Your ref: SSD 5175 MOD 1
Our ref: MC-12-1769

Section 96(2) modification request to amend the concept approval and stage 1 subdivision and early works for the Eastern Creek Business Hub

Issues for consideration – SSD 5175 MOD 1 for the 'Eastern Creek Business Hub'

Recommended additional and amended conditions of consent – SSD 5175 MOD 1 for the 'Eastern Creek Business Hub'

**TYPICAL BIO-RETENTION DETAIL**

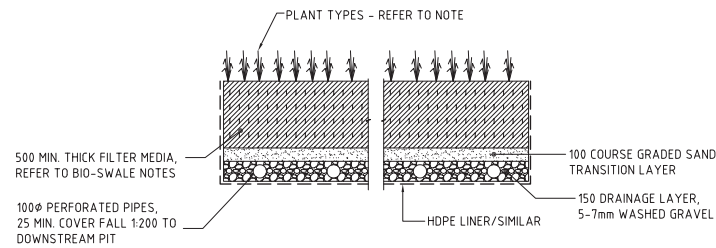
- To provide a water source to ensure ongoing viability of the bioretention plants a saturated zone is required comprising a 300 mm transition layer and a gravel layer sized as the larger of 200 mm, or 50 mm above the largest subsoil pipe. The saturated zone is set to the underside of the filter media and standard pit details are available from Council. On Costin Roe Plan CD12693.00-DA45(C) under "TYPICAL BIO-RETENTION DETAIL" amend the detail to match this requirement.

**TEMPORARY BIO-RETENTION PROTECTION DETAIL**

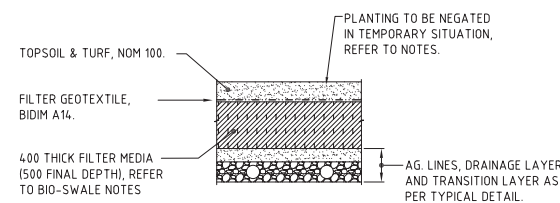
- i. On Costin Roe Plan CD12693.00-DA45(C) under "TEMPORARY BIO-RETENTION PROTECTION DETAIL" set the geotextile immediately above the transition layer (i.e. no filter media at all) with "COARSE SAND & TURF, NOM 100 - 150" above plus previous amendments as above. The bioretention notes are to be adjusted to match;

TYPICAL CHANNEL 01 SECTION  
SCALE 1:20

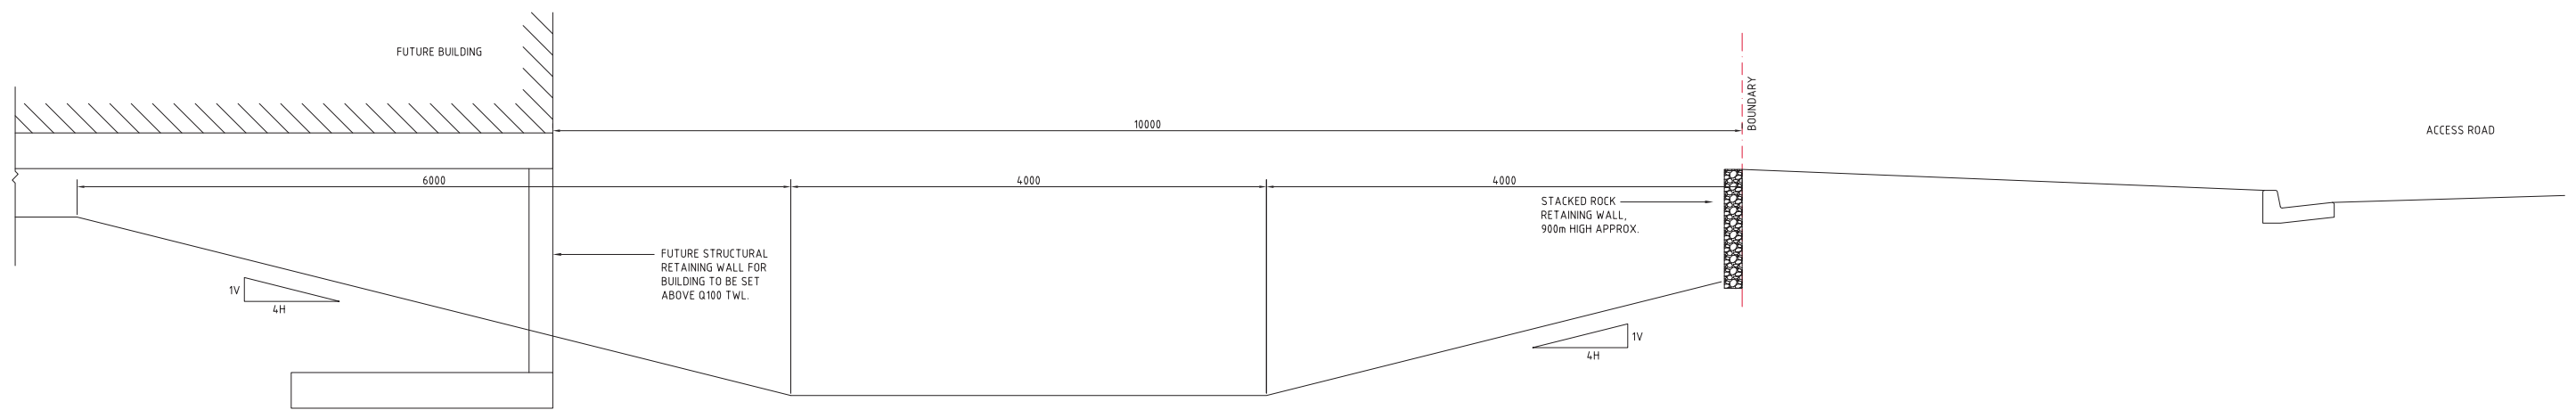
- Provide additional detailed sections through each of the channels clearly identifying batter slopes and finishes.
 - Redesign the culvert crossing of channel 01 to Pad 1 to assume a 50% blockage in the culvert. Where no blockage was previously assumed it is acceptable to double the culvert size to compensate. Details are to be provided.

- The channelization of the 100 year flows through Channel 01 to the existing creek will lead to increased scour and deterioration of the existing creek as previous high flows would have spread over a much wider area. A review of the geomorphology of the existing creek to cope with the increased flow is to be undertaken with recommended improvements detailed such as ponds and riffles, bank armouring of bends, scour protection, etc. as required.

- b. Provide a turf specie for channel 01 capable of sustaining a 1V: 3H batter. Detail any geogrids or other enhanced support to sustain such a steep batter slope.

RETAINING WALL PLAN  
SCALE 1:1000

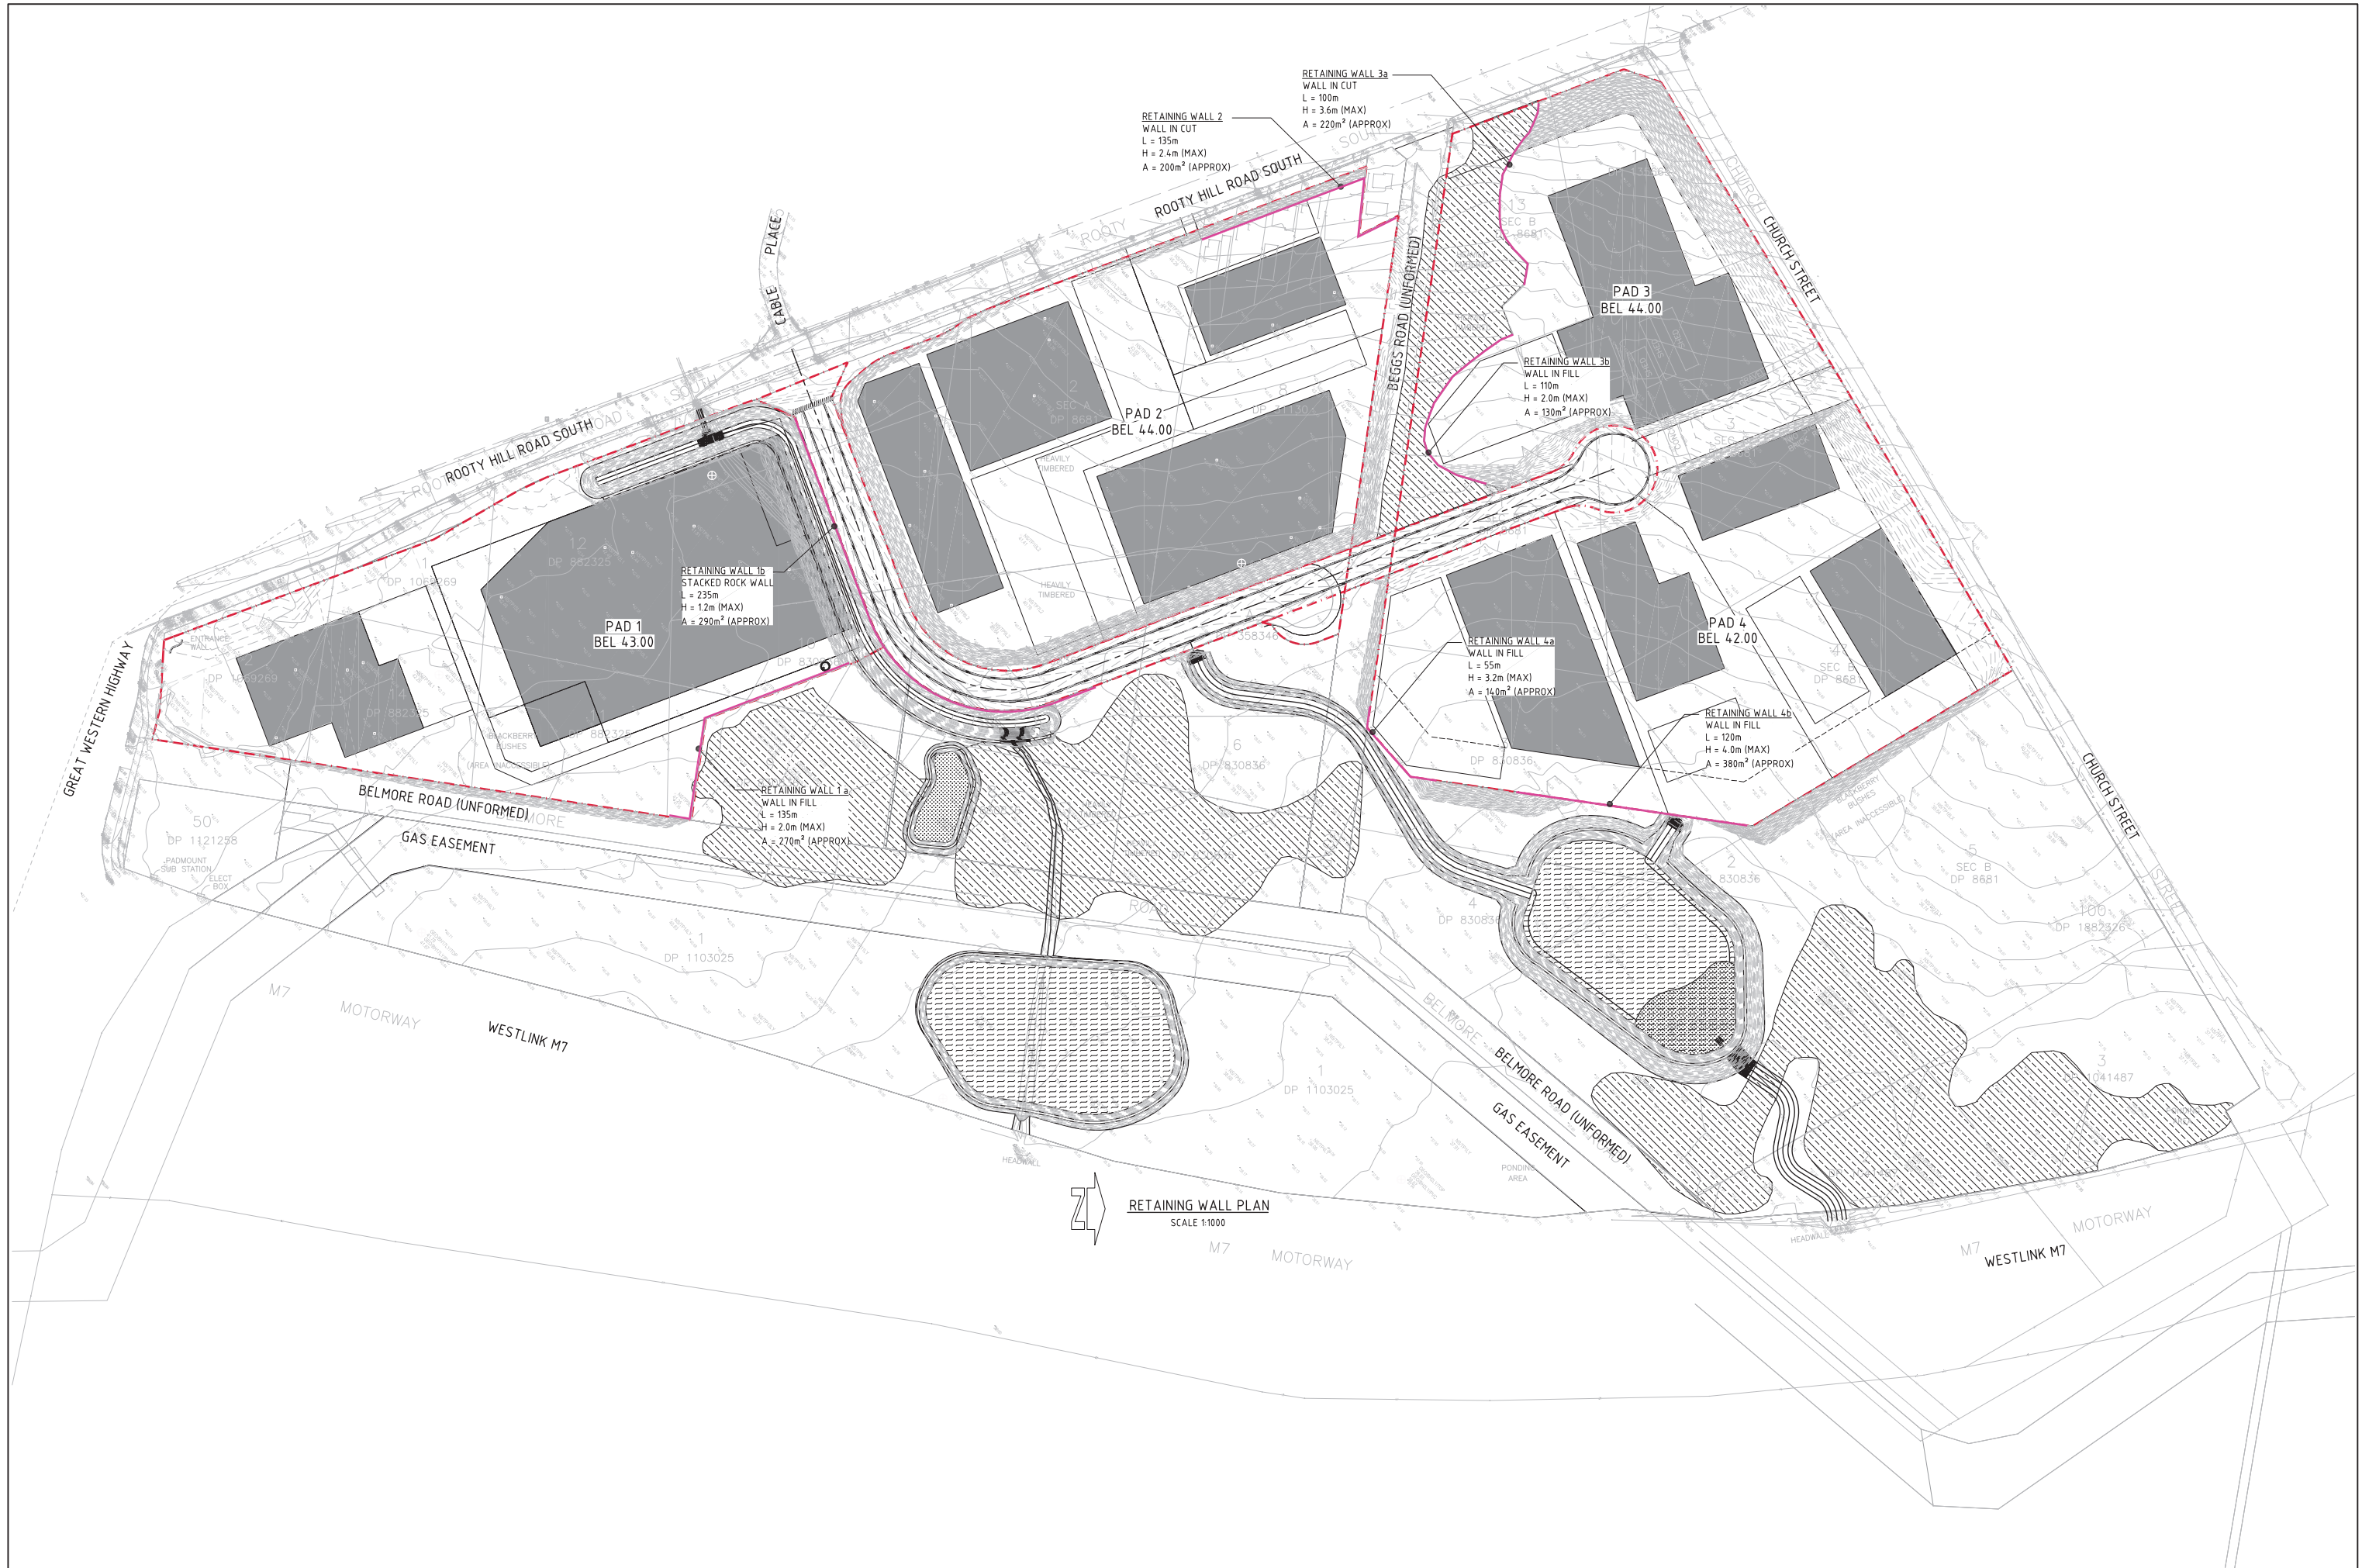
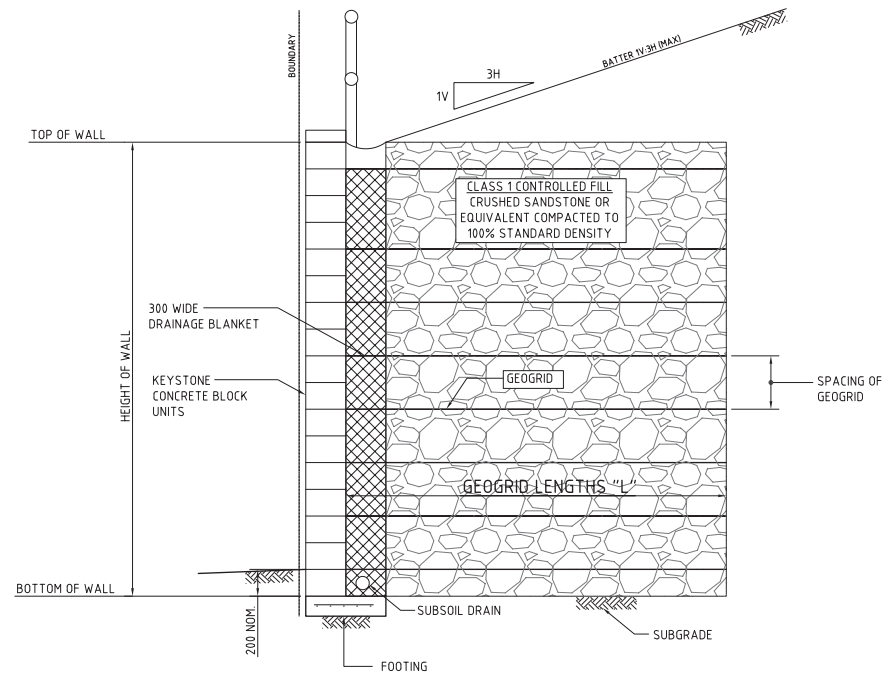
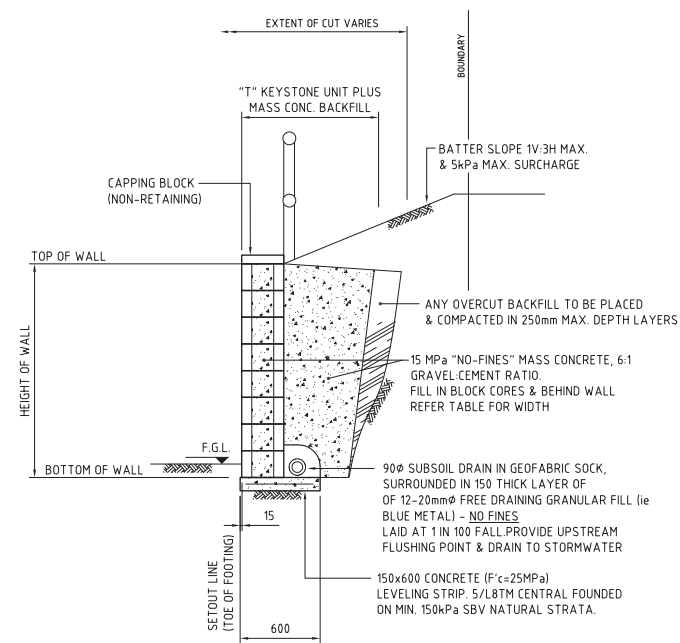
- B31. Details of any retaining walls, including height and material, to be constructed on site as part of the development are to be submitted to the Certifying Authority. Masonry retaining walls (i.e. no timber walls) are to be provided. All retaining walls shall be in maximum 3 metres high sections and stepped with 1 metre wide minimum planting bays which are to be landscaped. Where retaining walls 1.5m or greater are provided, these should not be provided in long expanses.
